From: ZAK JOMAA [REDACTED]
Sent: 16 May 2022 21:46
To: Kathryn Welch <Kathryn.Welch@arun.gov.uk>
Subject: Re: R/32/22/HH 30 The Parkway.

On Mon, May 16, 2022 at 4:42 PM Kathryn Welch <Kathryn.Welch@arun.gov.uk> wrote:

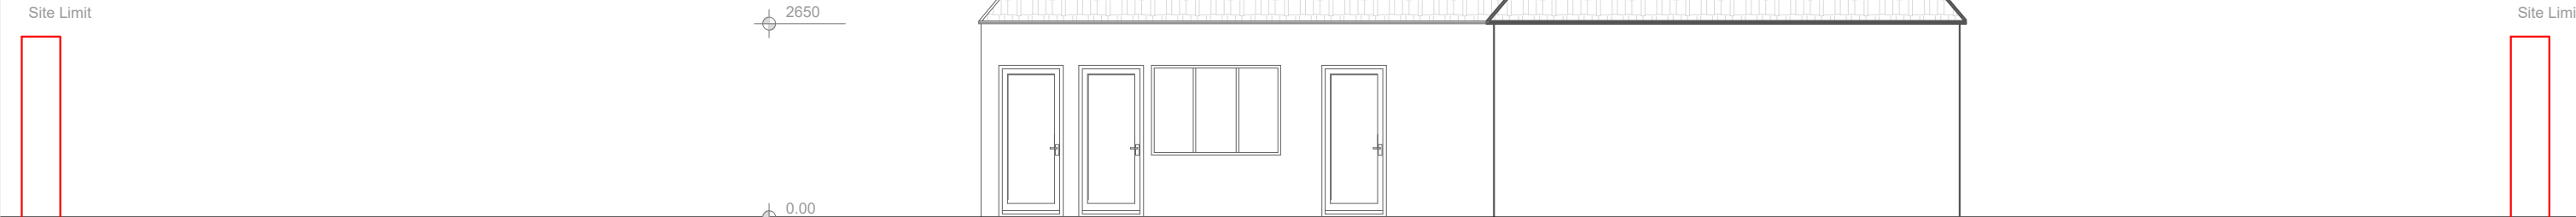
My biggest concerns are the various errors within the plans, namely errors in the roof plan and elevations which mean I can't approve the drawings, and the issues relating to the TPO tree on site. Solutions relating the development within the Root Protection Area should be put forward in any subsequent application.

I would therefore be grateful if you would withdraw the application by return in writing, and re submit once the amendments have been made.
